Rezoning Transportation Analysis

Petition Number: 2021-100

General Location Identifier: 02761107

Revision Log:

CONCEPT
SITE PLAN

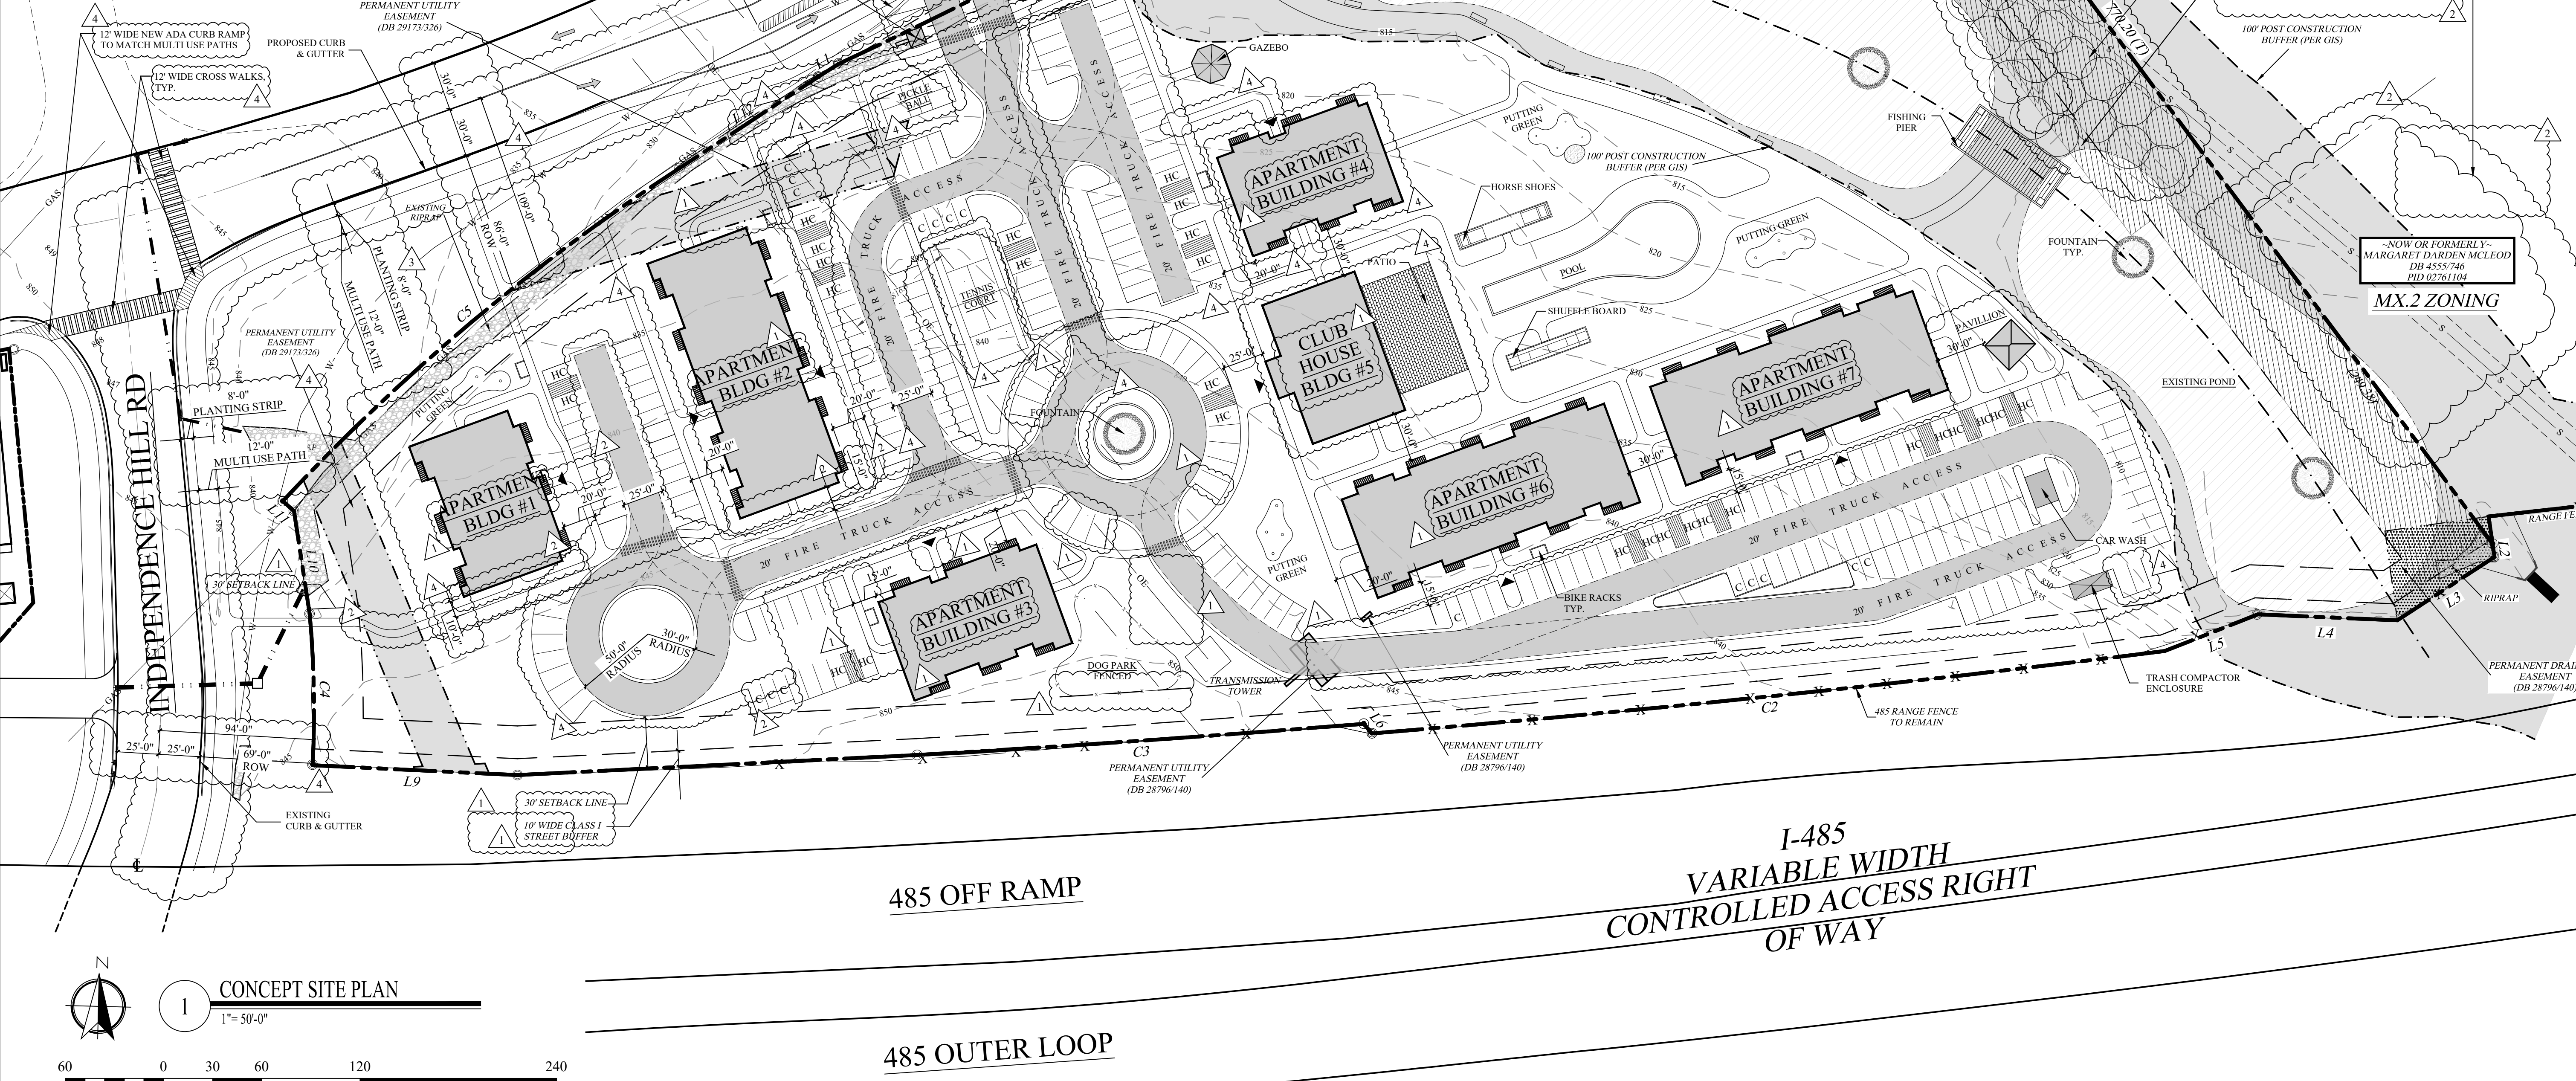
1. ~~Outstanding Comment from 9-22-21: The curbline along Eastfield Road shall be shown at 30' from centerline to back of curb. Revise site plan to reflect this condition and label and dimension the right-of-way and curb and gutter from the Eastfield Road centerline.~~
~~Outstanding Comment from 11-22-21: Add labels/callouts for the ROW and the proposed curb and gutter. Dimension the ROW on Eastfield Road from the centerline.~~

3. ~~Outstanding Comment from 9-22-21: Revise site plan and conditional notes to label and describe location of the existing curb location and right of way along Independence Hill Road. The site plan shall label and dimension the curb and right of way from the road centerline.~~

4. ~~Revise site plan to construct 8-foot planting strips and 12-foot multi-use paths on Eastfield Road and Independence Hill Road. The site plan shall label and dimension both items from the back of curb and gutter and road centerline. Add conditional note committing to construction and maintenance of the 8-foot planting strips and 12-foot multi-use paths on Eastfield Road and Independence Hill Road since property is in the ETJ. A maintenance agreement will be required for these facilities.~~
~~Clarifying Comment from 9-22-21: Current plan shows 6' back of curb sidewalk along Eastfield and Independence Hill Roads. Revise site plan and add conditional note to construct 8-foot planting strips and 12-foot multi-use paths on Eastfield and Independence Hill Road frontages. Two new curb ramps will be need to be constructed on the southeastern corner of Independence Hill Road and Eastfield Road at a width of 12' for each to match the MUP's. Add conditional note committing to construction and maintenance of these facilities.~~

~~Outstanding Comment from 11-22-21: Label and dimension MUP along Independence Hill Road. Add conditional note(s) committing to construction and maintenance the MUP facilities along Eastfield Road and Independence Hill Road. In addition, revise site plan to show additional ADA ramp to cross Eastfield Road on the southeastern corner of the Independence Hill Road and Eastfield Road intersection.~~

6. ~~Revise site plan and add conditional notes showing access points off Eastfield Road and Independence Hill Road to be right in right out only.~~
~~Clarifying Comment from 9-22-21:~~ Per email dated 09-28-2021 from Wendy Taylor, a 100' RTL and 150' LTL were added for the access point off Eastfield Road. Show existing striping on Eastfield Road and show the existing LTL taper shortened from Eastfield Road to Independence Hill Road and create a striped section separating the two LTLs.
~~Outstanding Comment from 11-22-21:~~ Add conditional note(s) committing to the 100' RTL and 150' LTL.
